Our Ref: EN010085

Date: 3 April 2020

Application by Cleve Hill Solar Park Limited (“the Applicant”) for an Order granting Development Consent for the proposed Cleve Hill Solar Park and associated infrastructure (“the proposed Development”)

REQUEST FOR INFORMATION

Sheet 2 of 5

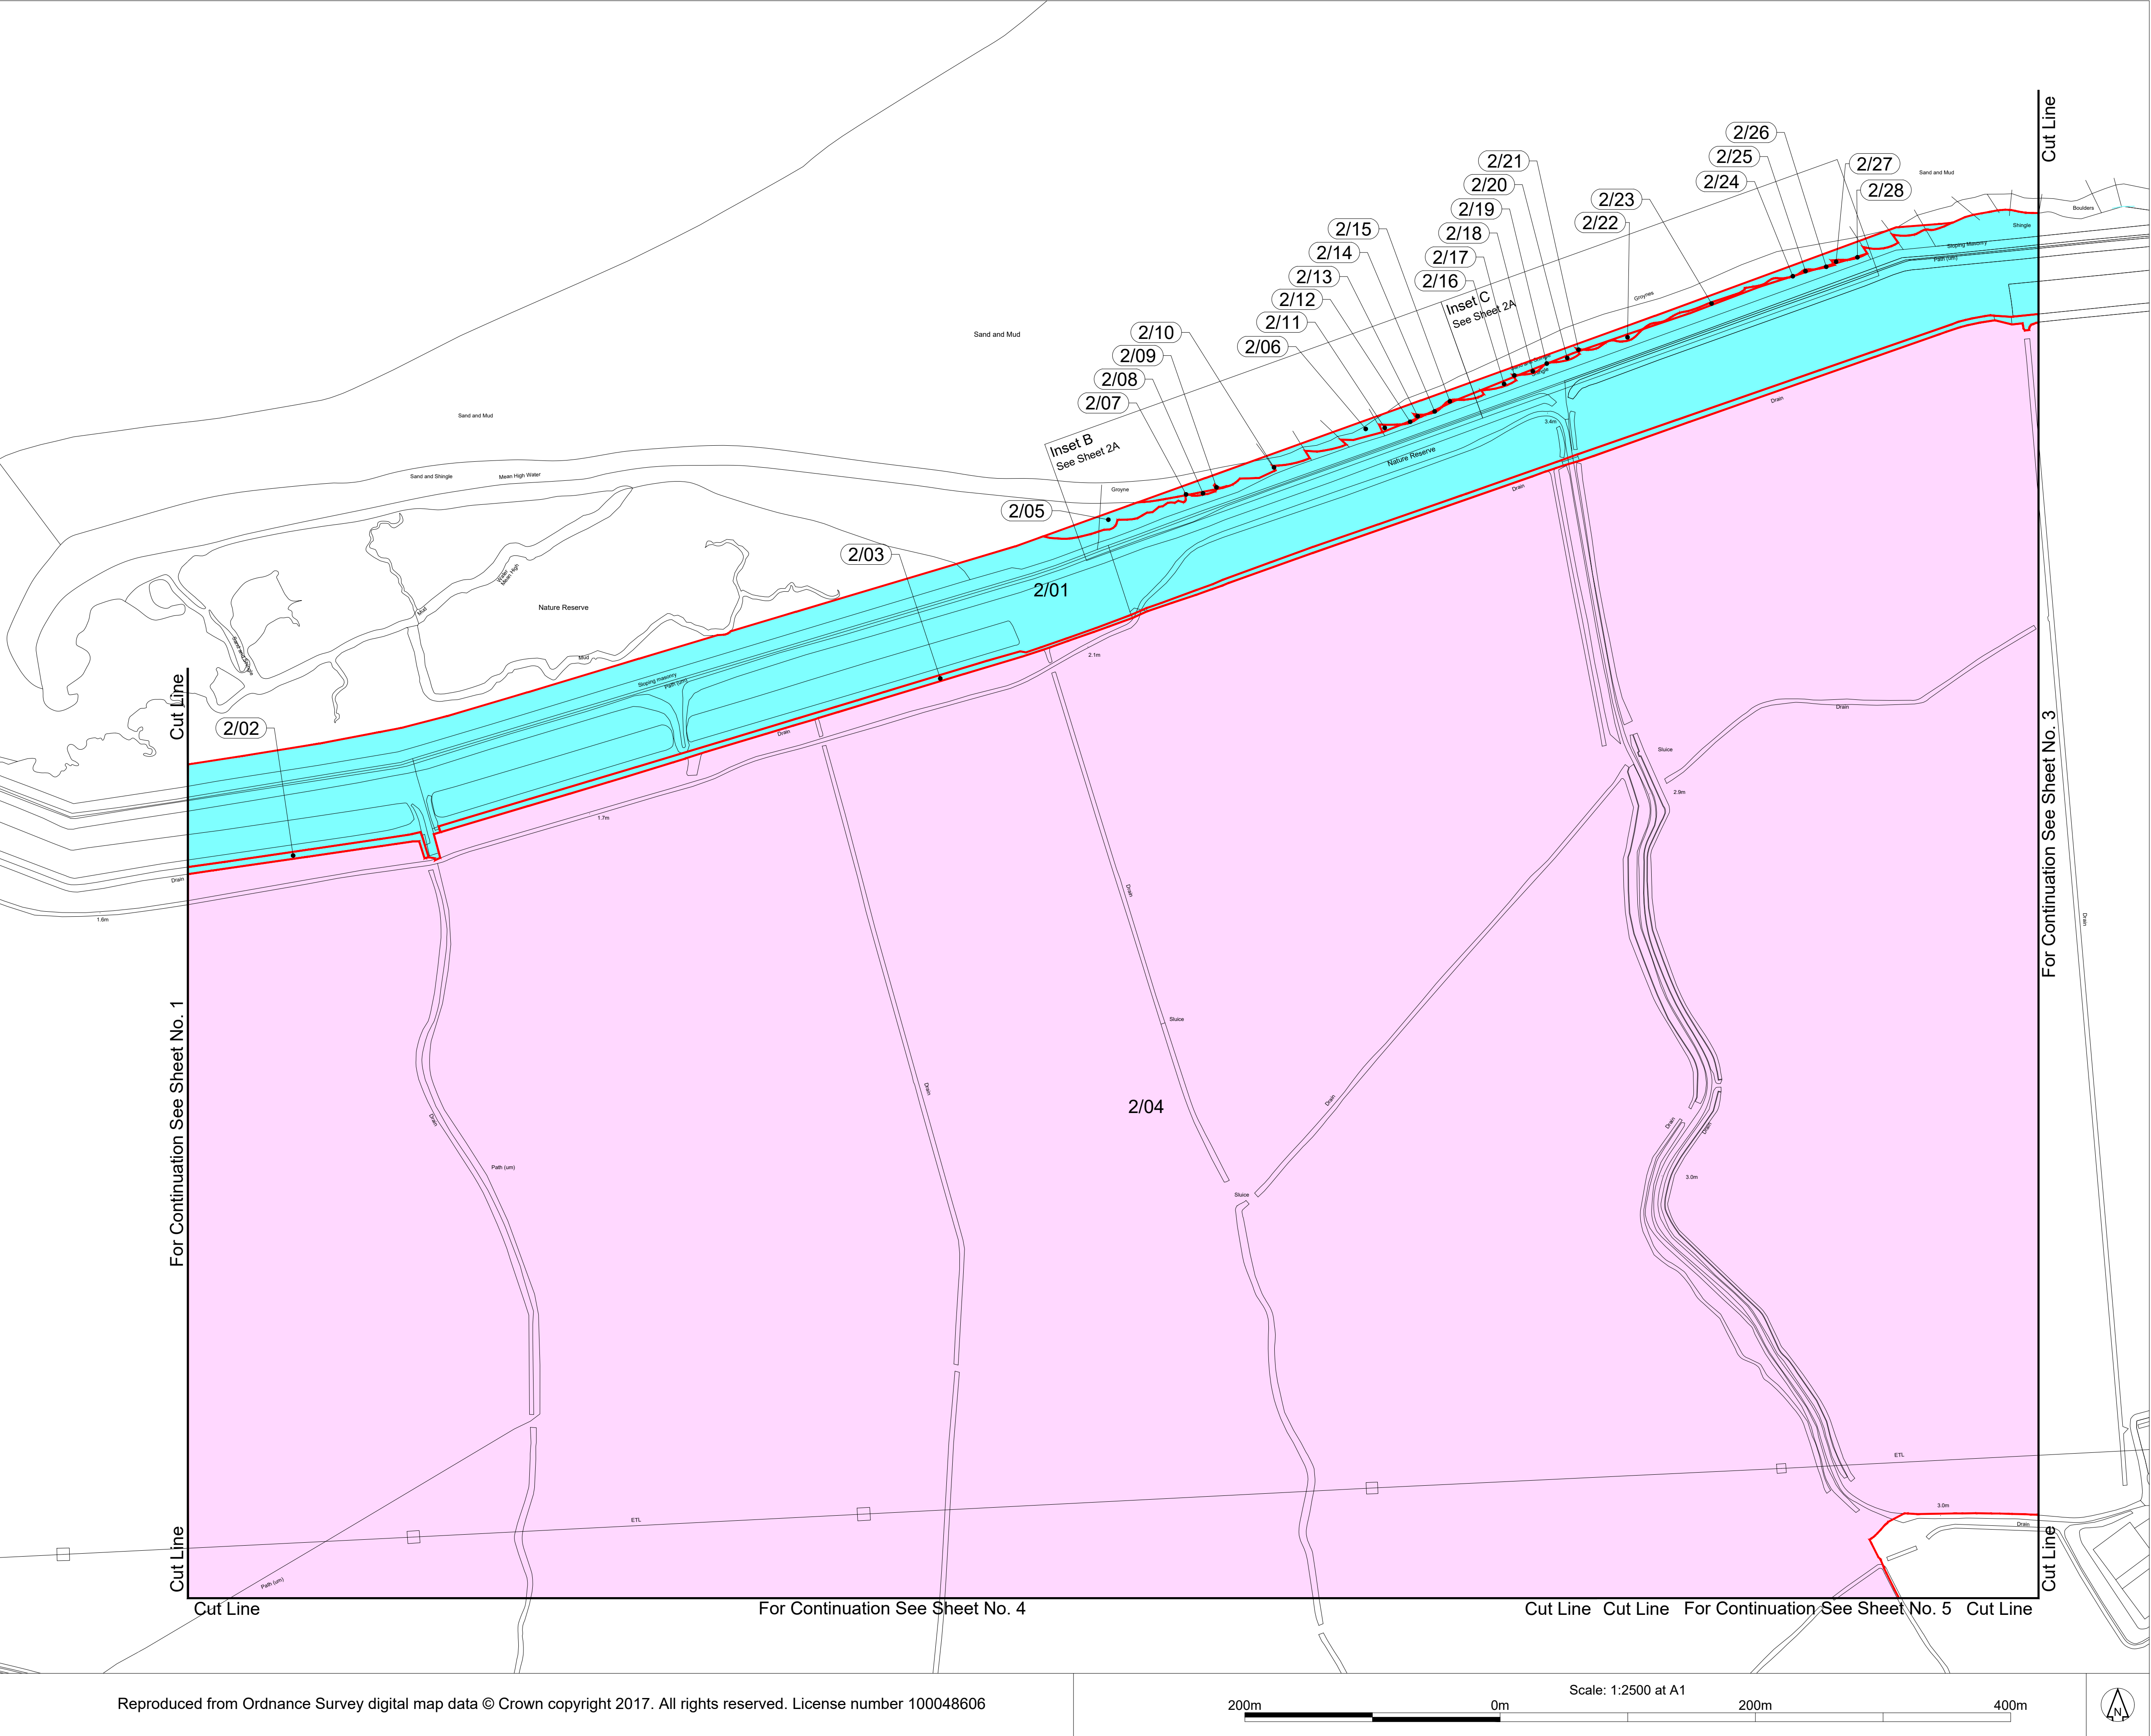
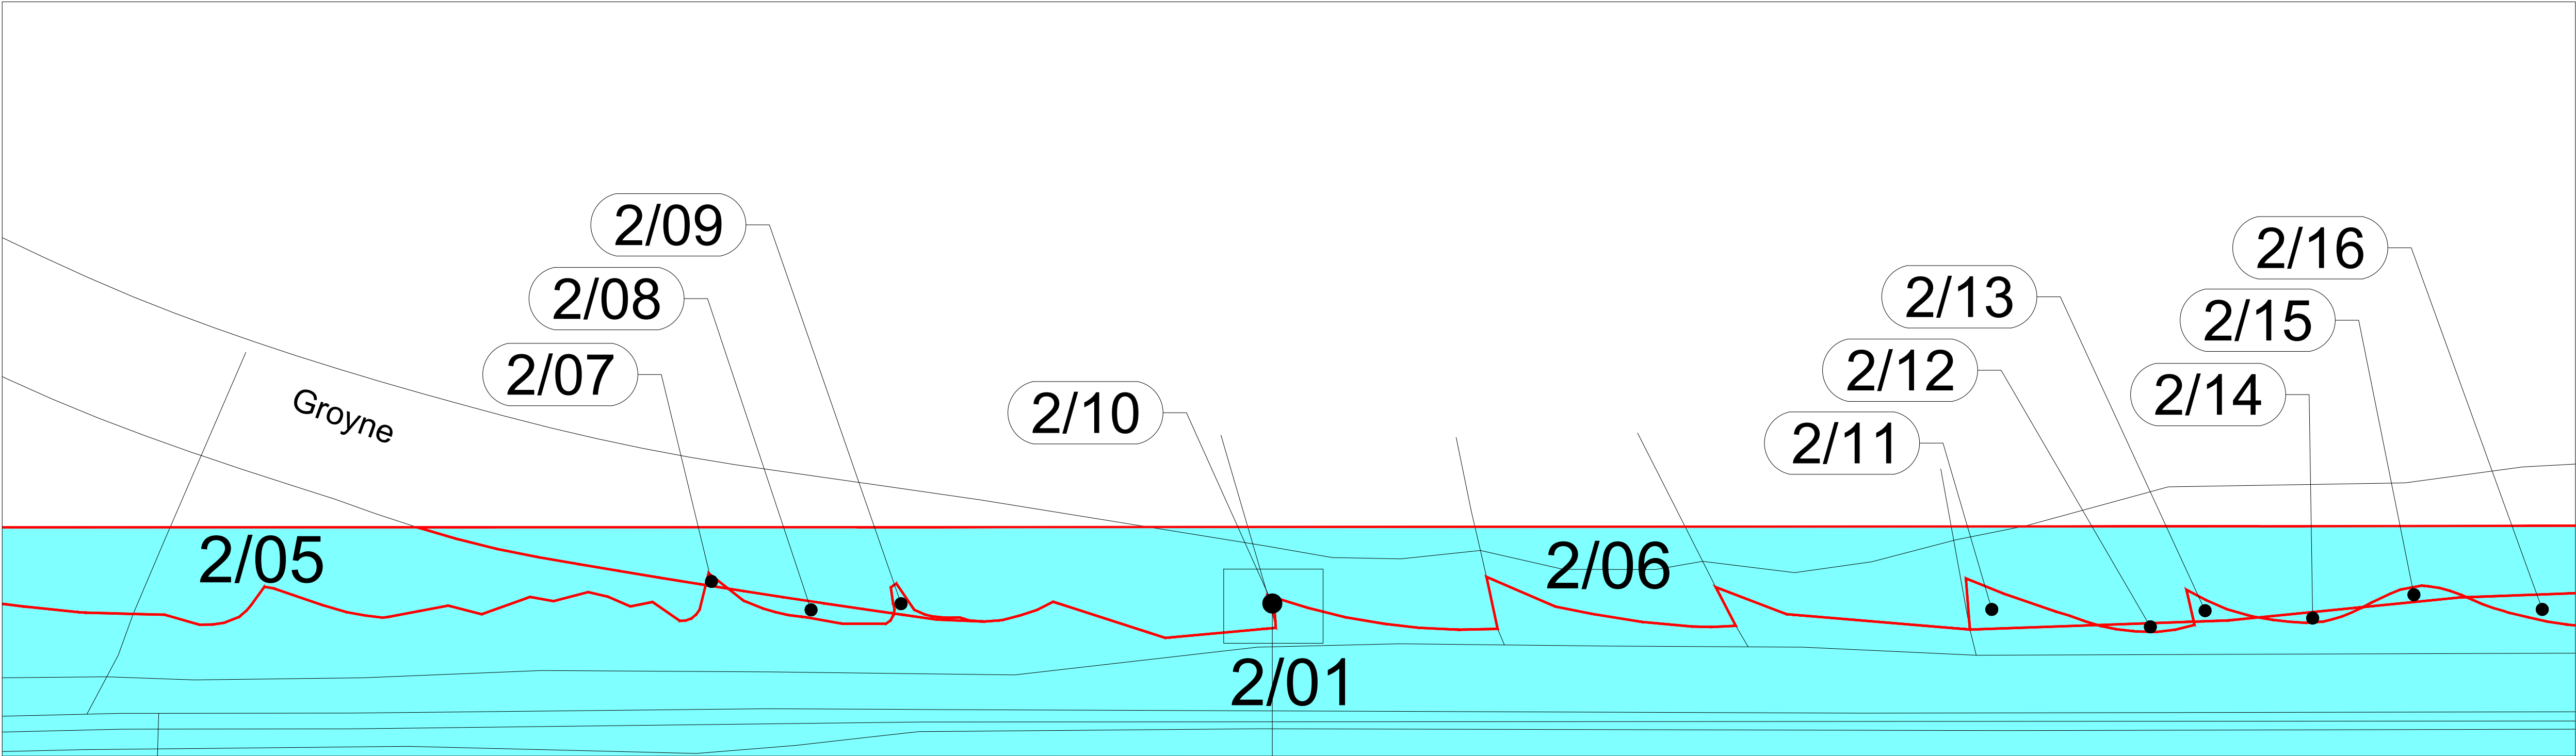
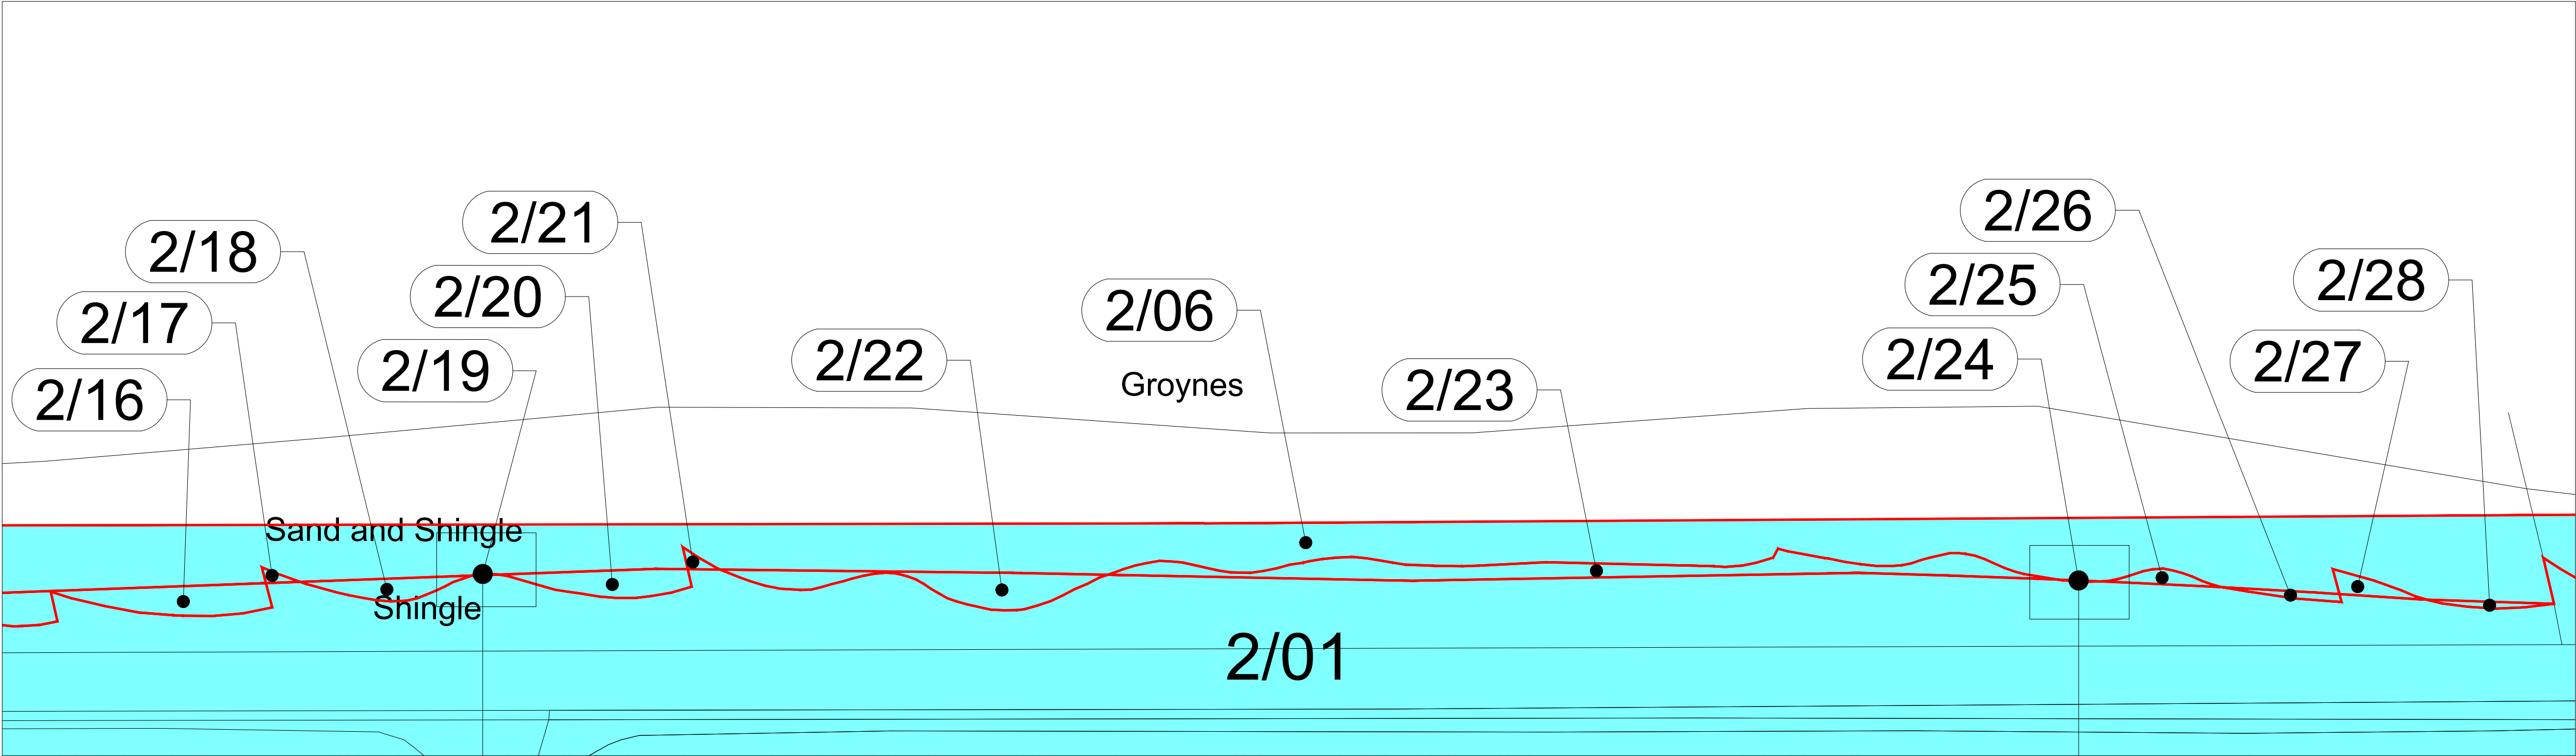
5. The Secretary of State notes from the Applicant's Statement of Reasons ("SoR") submitted with its application for development consent [see link below to final version of the Statement of Reasons on the PINS web-site] that compulsory acquisition powers are sought over a plot of land numbered 5/03 in the SoR and shown on the relevant Land Plan submitted by the Applicant in relation to the provision of land for "solar array, energy storage facility electrical connection, HMA [Habitats Management Area] and access" (link also attached below) .

7. The Secretary of State is considering whether the Lowland Grass Meadow Habitat Management Plan that is proposed in plot 5/03 meets the requirements of section 122 of the Planning Act 2008. The Secretary of State is minded to conclude that the compulsory acquisition of plot 5/03 should be confirmed only in respect of Works numbers 1 and 4 in the event that the DCO is granted. The Secretary of State requests the **Applicant’s** view on whether limiting the compulsory acquisition powers sought over plot 5/03 to Works 1 and 4 in any DCO that might be issued is appropriate.

8. The **Applicant** is, in any case, requested to provide revisions to the Land Plan and Book of Reference, including a revised Plot Reference and Description of Land, and for these to be included in the List of Certified Documents.

9. The **Applicant** is also requested to provide the Secretary of State with an accurately marked site boundary within plot 5/03.
